Date: 21 September 2021

**Application by Highways England for an Order Granting Development Consent  
for the A47 Blofield to North Burlingham scheme**

**Request to make changes to the original application**

Drawing Number	Rev
Highways England PIN	
HE551492-	P05
GTY-LLO-000-DR-BL-00005	
Location

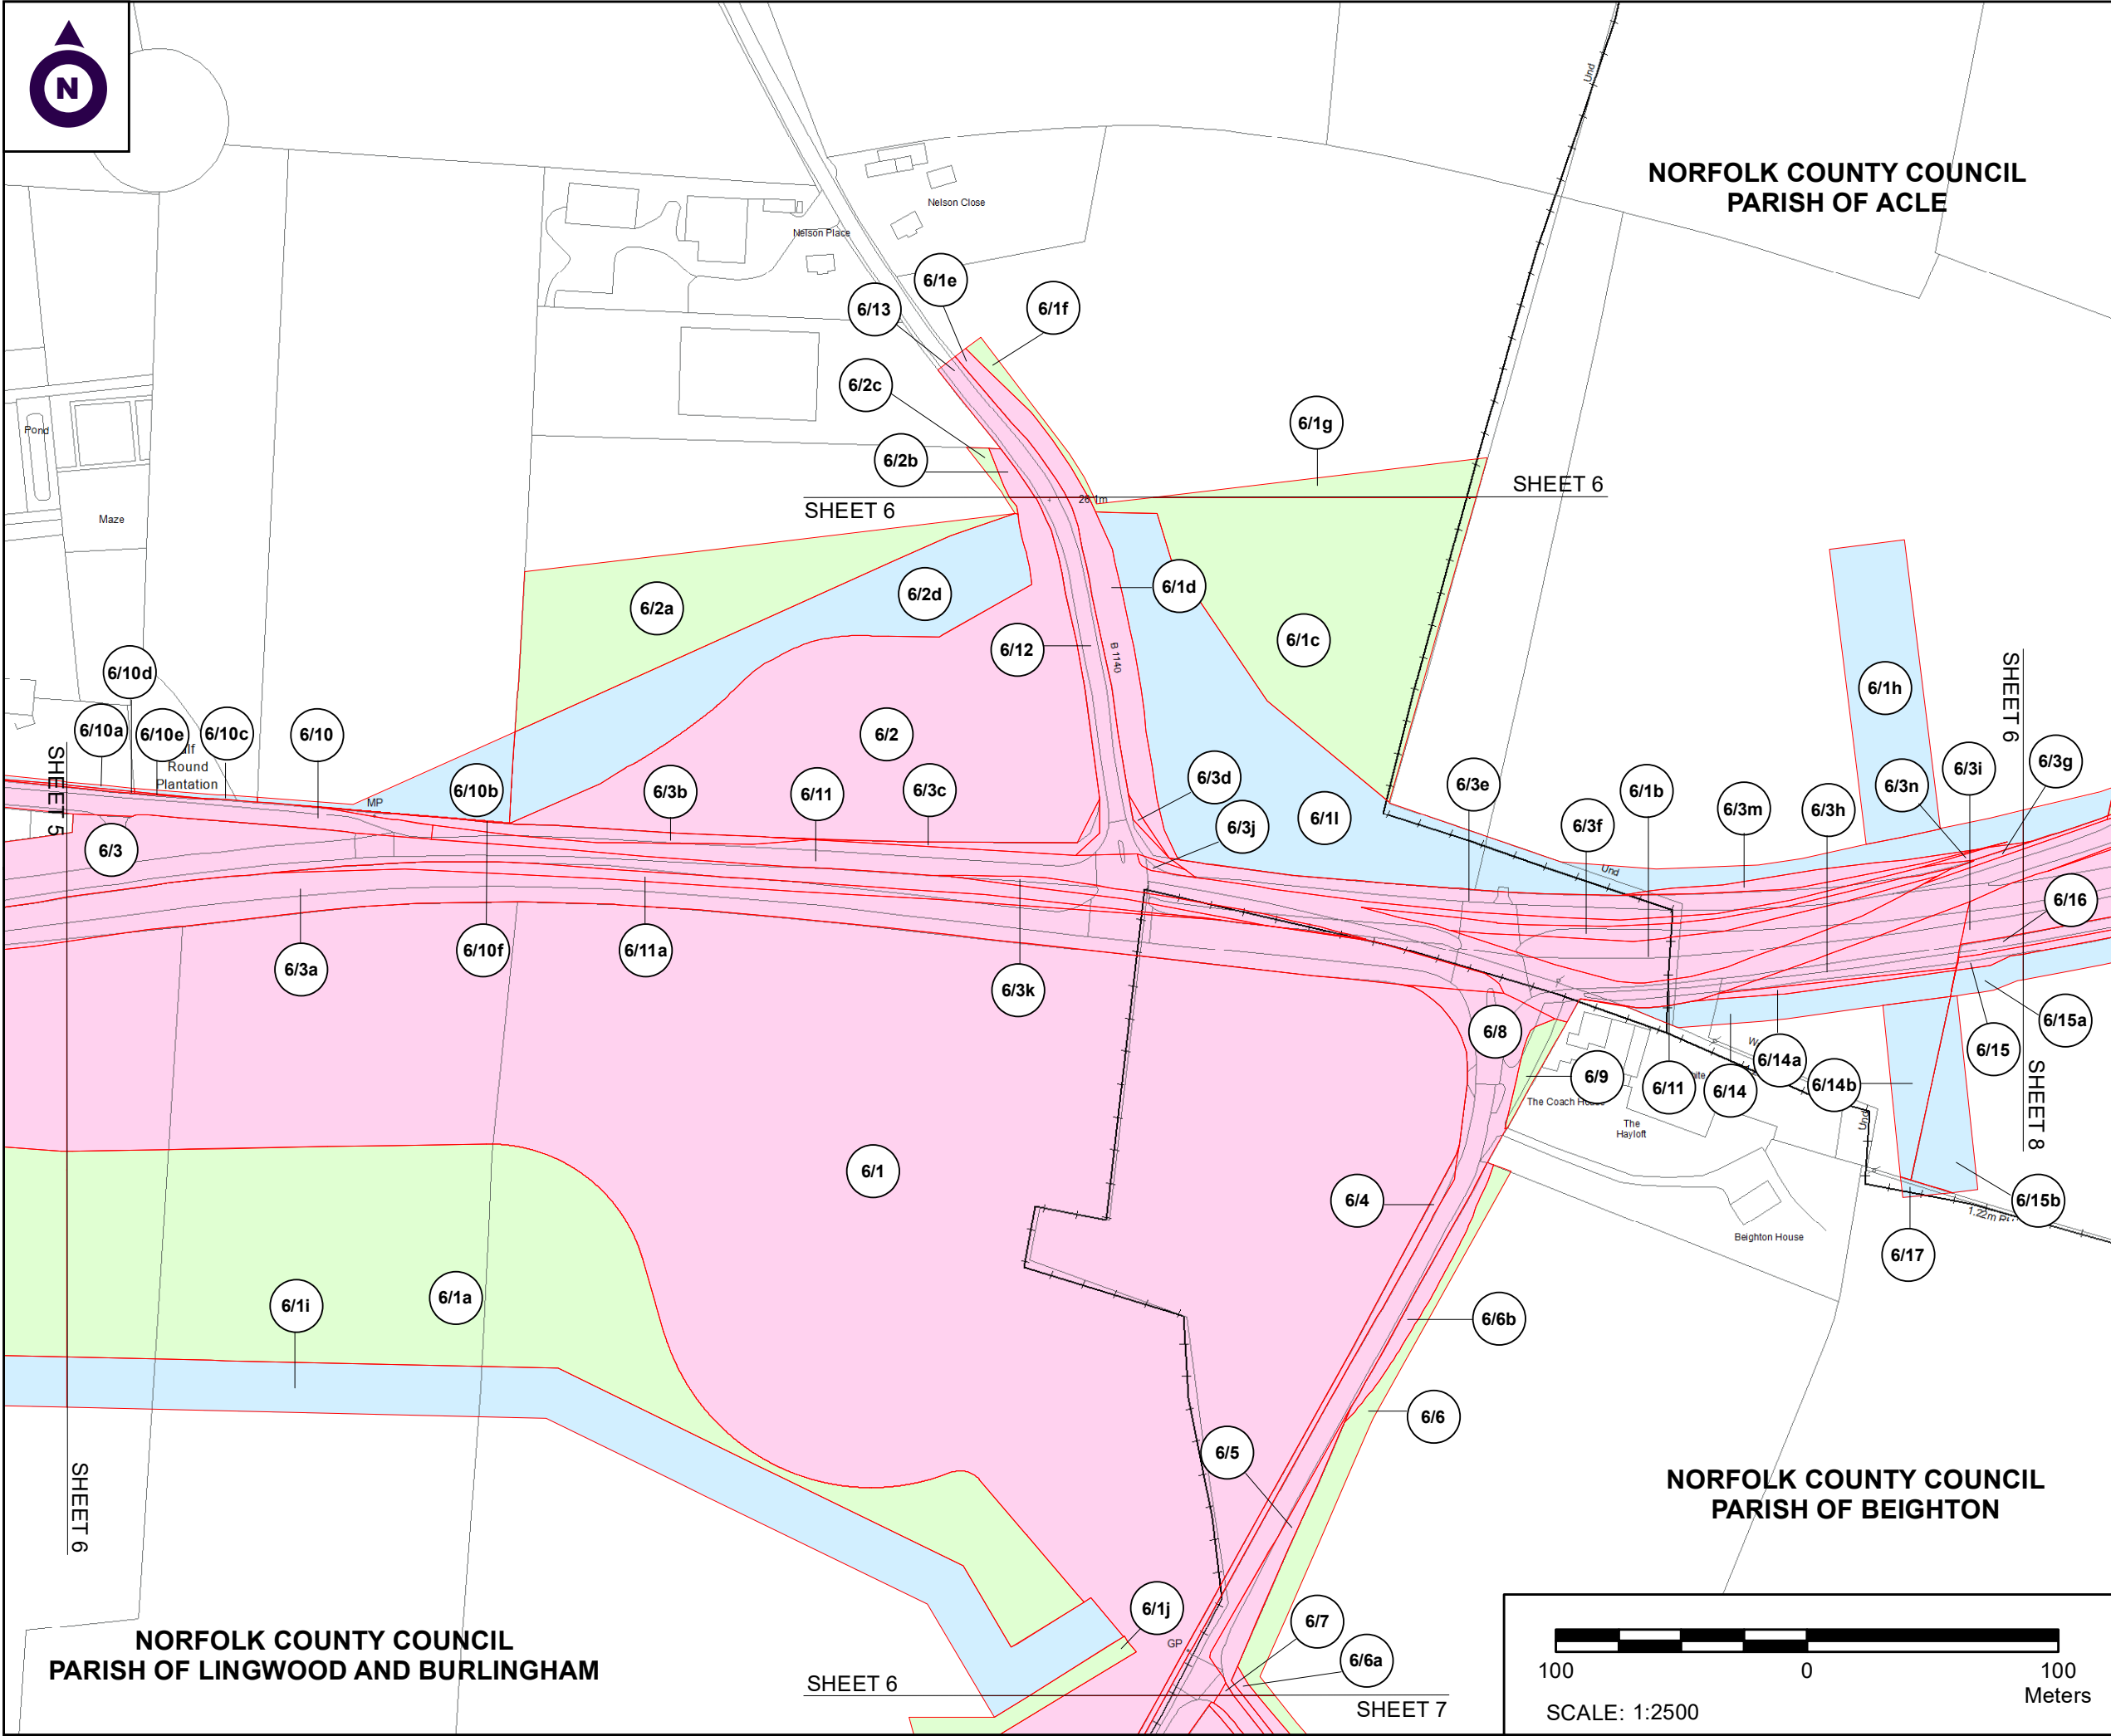
- The re-provision of an existing block valve compound belonging to Cadent Gas Limited, which is situated adjacent to and to the south of the current A47 (Plot 5/2 on sheet 5 of the Land Plans Rev 1), on a new site further to the south (Plot 5/1e on sheet 5 of the Land Plans Rev 1);

- The provision of new access to the new block valve compound site; and
- To provide for the new block valve compound site and access to it, the subdivision of Plots 5/1a and 5/1b (on Sheet 5 of the original Land Plans [APP-005]) to create Plots 5/1a, 5/1b, 5/1c, 5/1d, 5/1e and 5/1g (on Sheet 5 of the Land Plans Rev1), with the following implications:

- Plot 5/1b – change from Temporary Possession (green) to Temporary Possession with Rights to be Acquired Permanently for access purposes (blue);
  - Plot 5/1e – change from Temporary Possession with Rights to be Acquired Permanently (blue) to Compulsory Acquisition (pink); and

- Plot 5/1g – change from Temporary Possession with Rights to be Acquired Permanently (blue) to Temporary Possession with additional Rights to be Acquired Permanently for access (blue).

planting elsewhere) with little explanation as to the reasons for this, or potential effects of this, particularly given the affected area of woodland appears to lie outside of Plot 5/1e; and

- The response of Cadent Gas Limited at Annex 1 of the 'Request for a Non-Material Change to the Application Rev 1' indicates that there is a 'very large oak tree' which may affect the proposed siting of the new block valve compound. The implications of this, including for the tree and for the proposed siting of the new block valve compound, including whether it could be accommodated within the identified plot if the tree were to remain, are unclear to me.

- The power to compulsorily acquire or impose new access rights over Plots 5/1b, 5/1e and 5/1g did not form part of the original application;
- The change thus involves 'additional land' for the purposes of Regulation 4(a) of the CA Regulations; and

- There is no evidence that Category 2 persons identified in the Book of Reference Rev 4 as having an interest in Plots 5/1b, 5/1e and 5/1g have been consulted on the proposed change and that they consent to the inclusion of the provision and additional powers sought.
